PLANNING AMENDMENT

H08-0118-20

Extension to form dining Room

19/cw/03

Drawing Number: 19/CW/03	Rev:
Project Number:

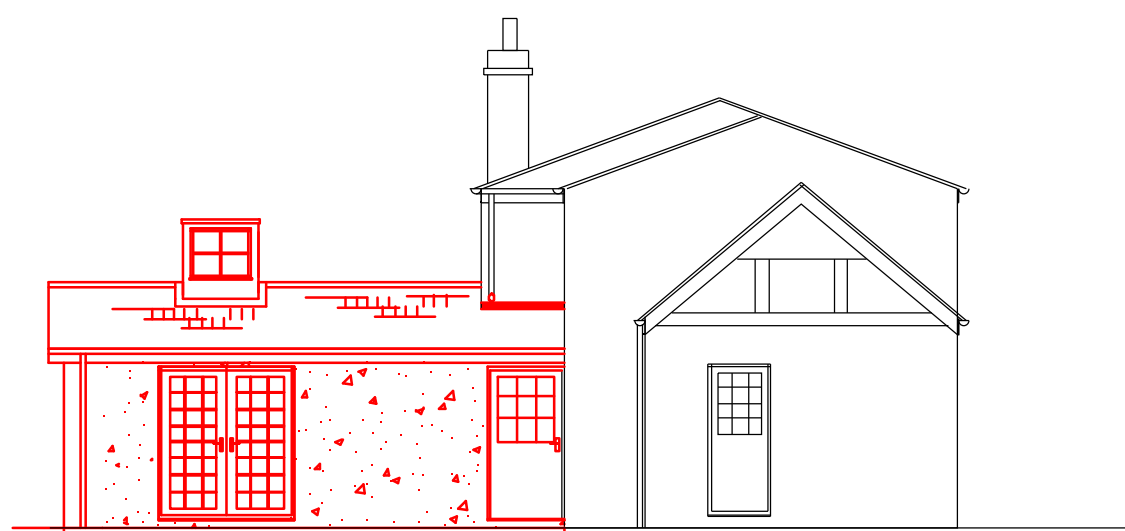
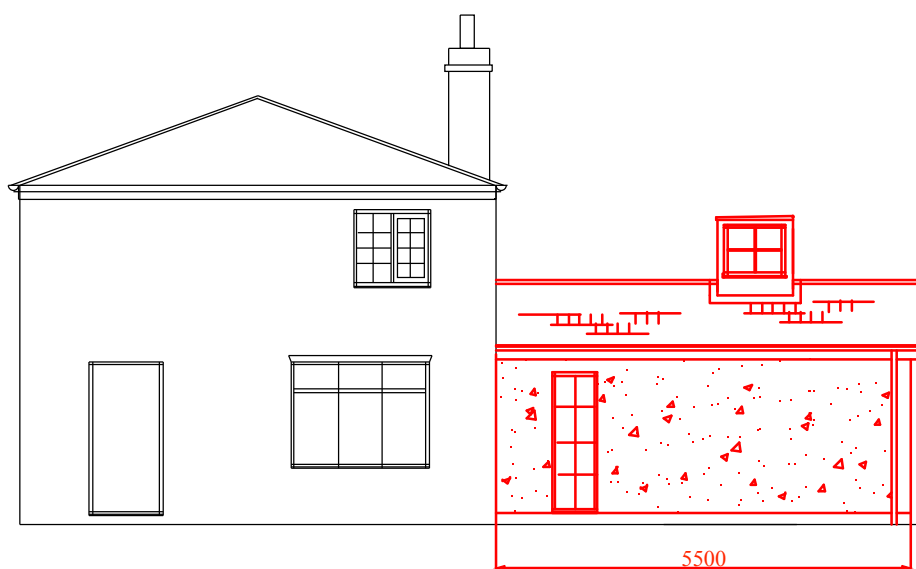
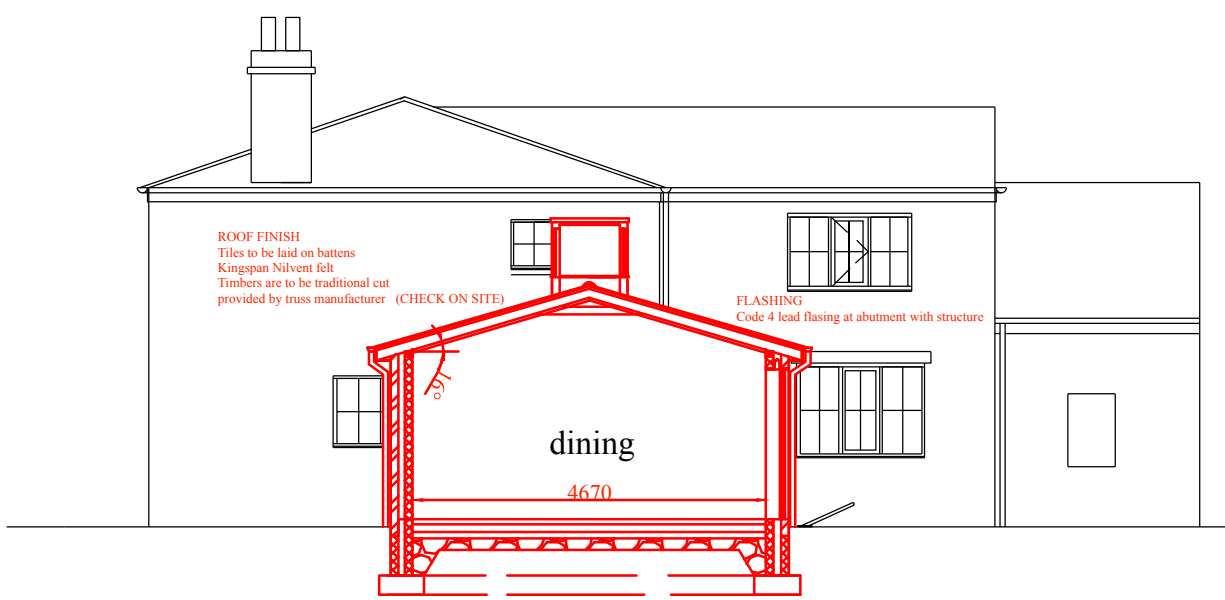
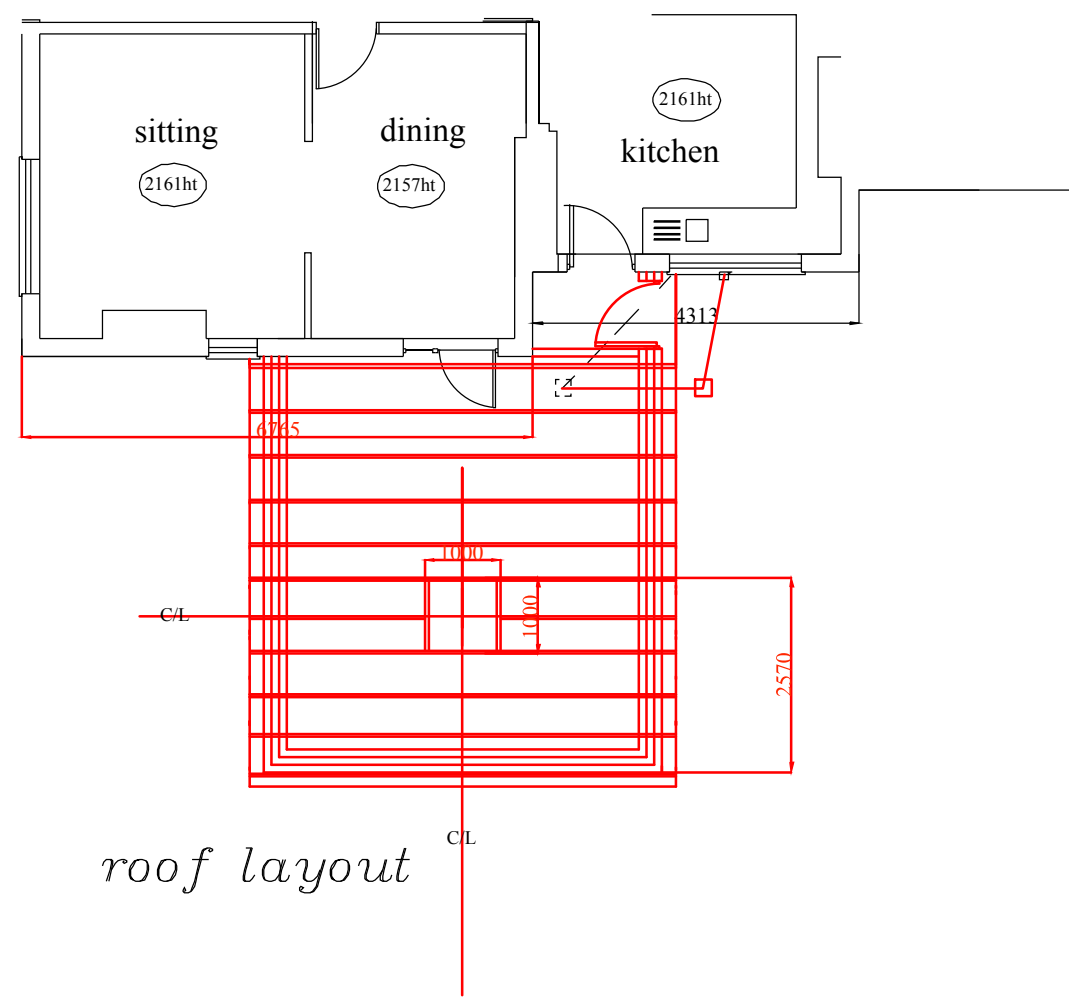
Roof Turret to have flat top rather than pitched thus reducing the height.
